Response to Planning application from Hertfordshire County Council (T and CP GDP Order 2015)

District ref: 6/2020/2857/FULL
HCC ref: WH/4166/2020
HCC received: 11 November 2020
Area manager: Matthew Armstrong
Case officer: Paul Marshall

73 PINE GROVE HATFIELD AL9 7BL

AMENDED PROPOSAL

Drawing Number 73PG-11	Revision J
---------------------------	---------------

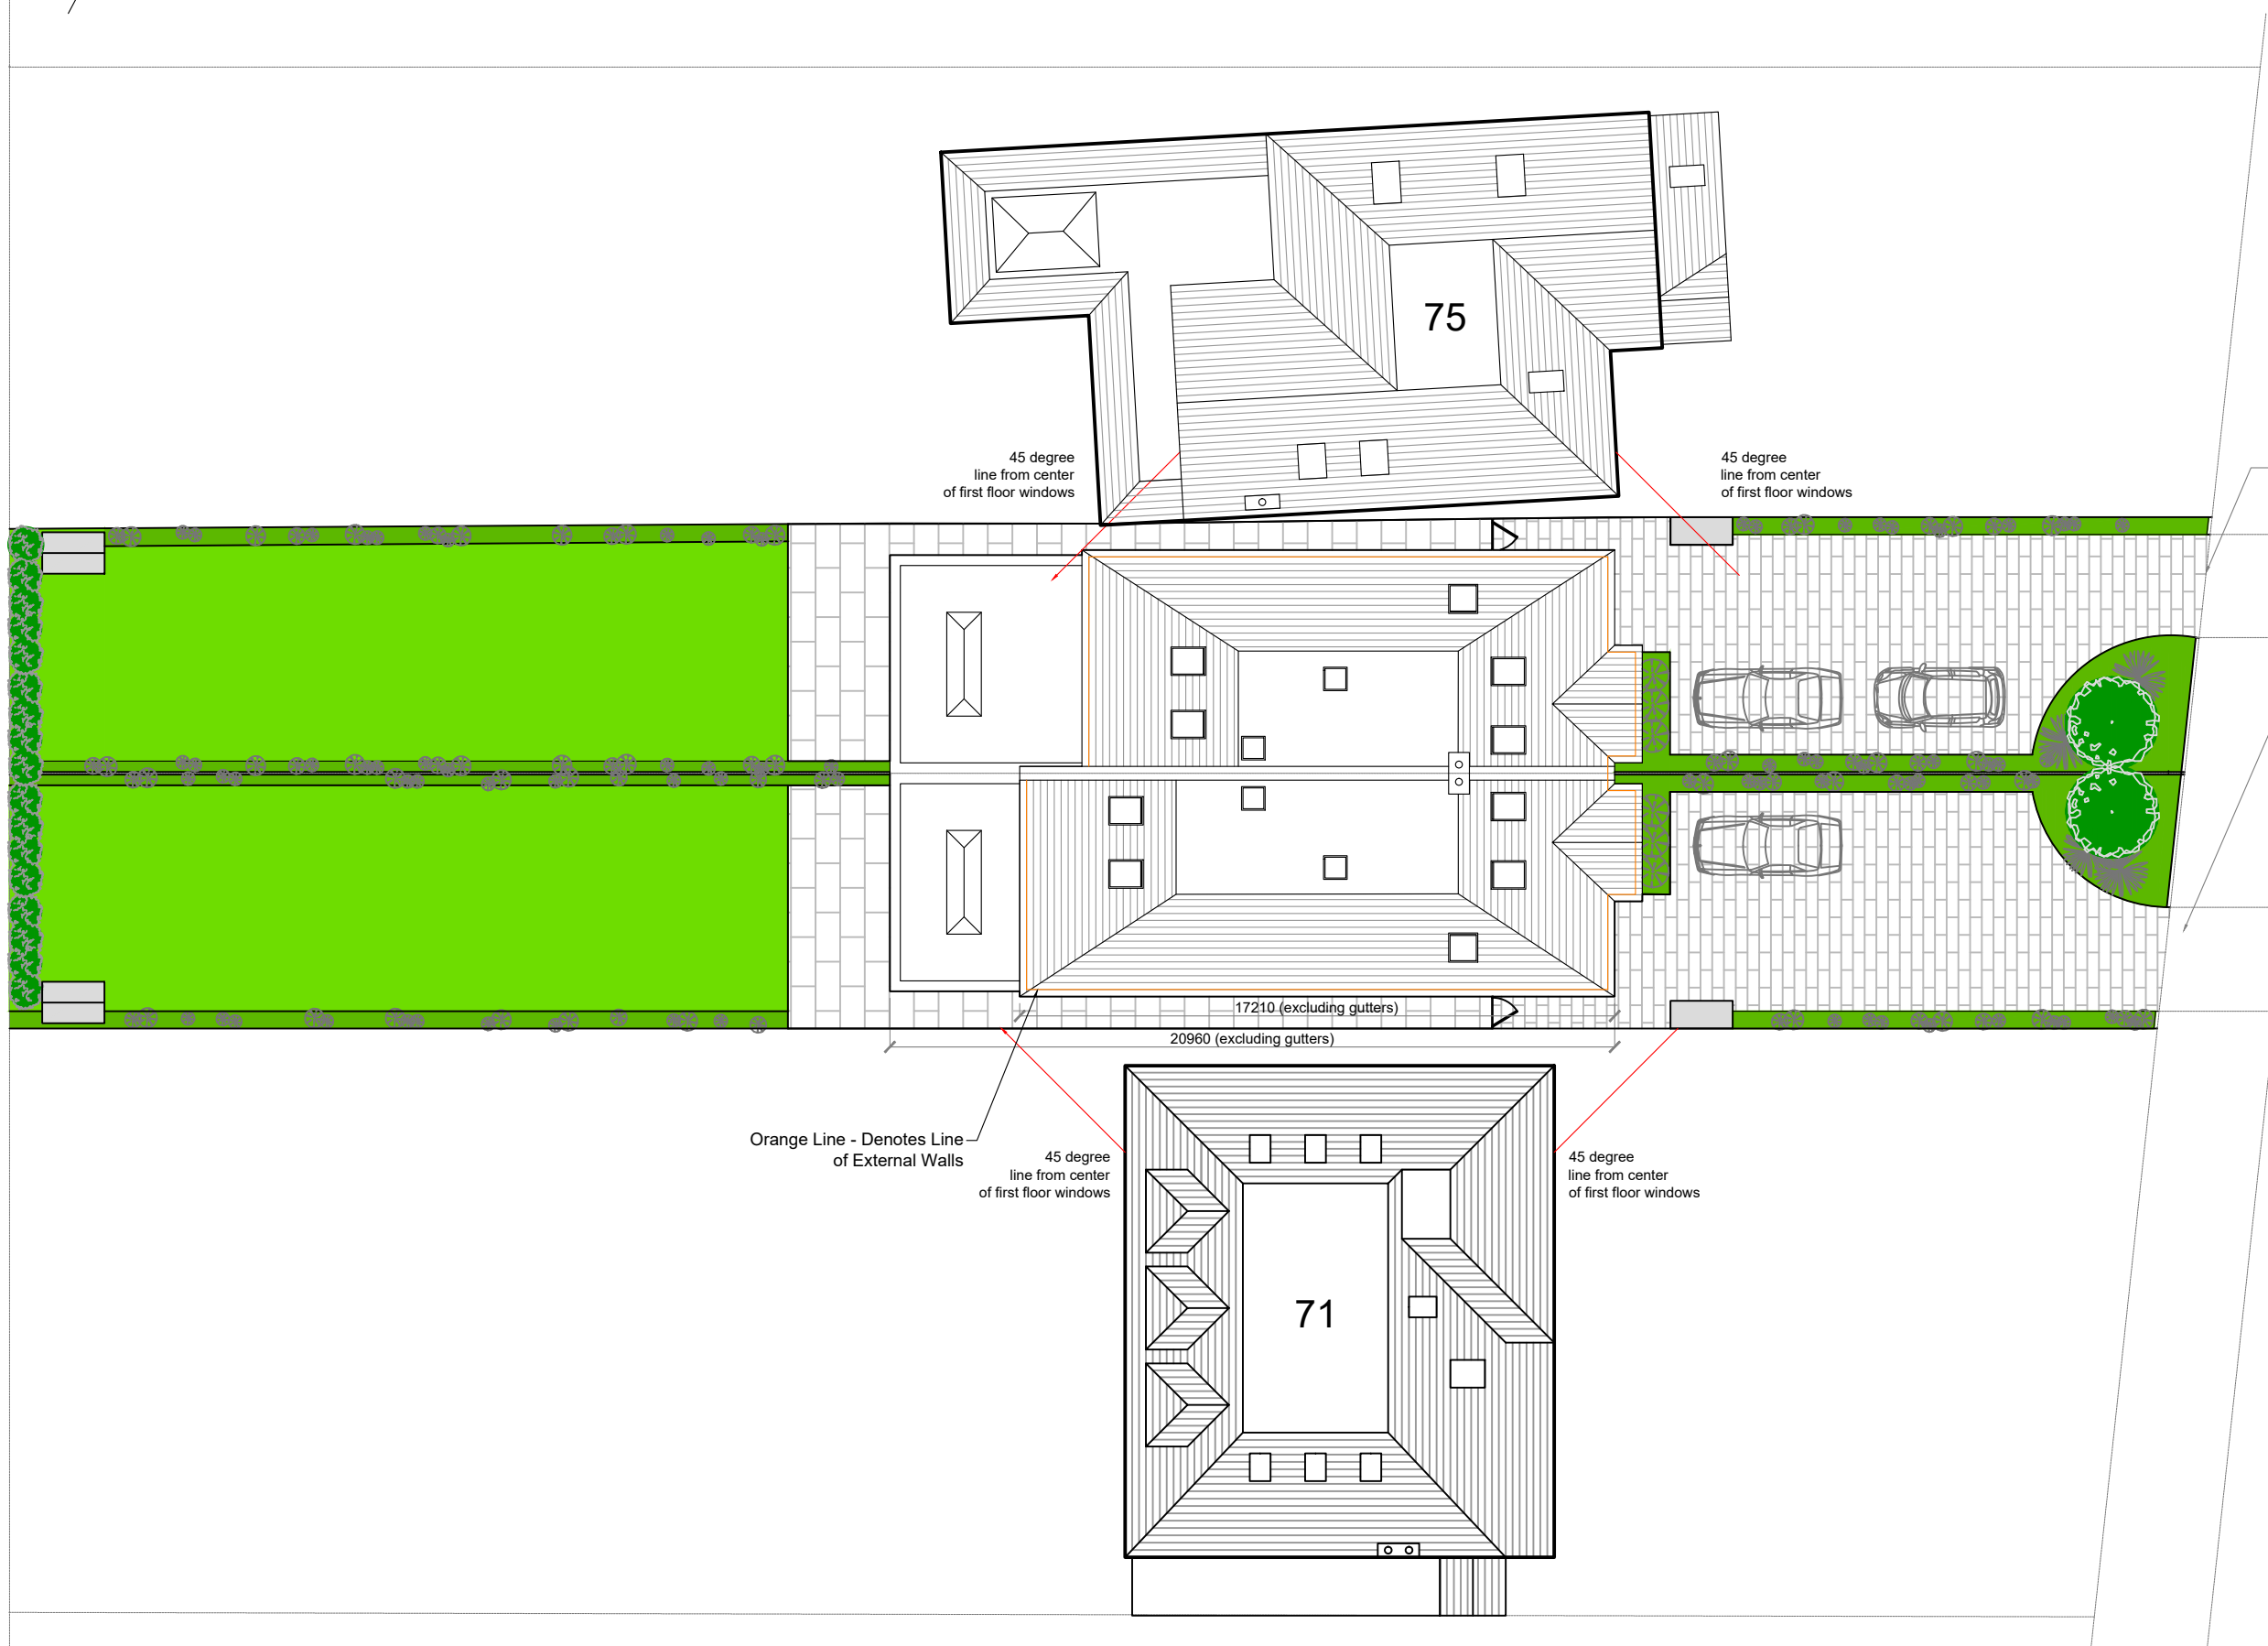
CON1) Prior to the first occupation of the development hereby permitted the vehicular access shall be provided and thereafter retained at the position shown on the approved plan drawing number (73PG-49 Rev A) Arrangement shall be made for surface water drainage to be intercepted and disposed of separately so that it does not discharge from or onto the highway carriageway. Reason: To ensure satisfactory access into the site and avoid carriage of extraneous material or surface water from or onto the highway in accordance with Policy 5 of Hertfordshire's Local Transport Plan (adopted 2018).

An existing access is in place for no 73 'A' and a new access is proposed for no 73. Drawing 73PG-49 Rev A. demonstrates the width of the proposed dropped kerb as approx. 5.1m. Applicant should be aware of HCC Dropped Kerb Terms and Conditions will only build a single at 4.5m and a double at 5.4m.
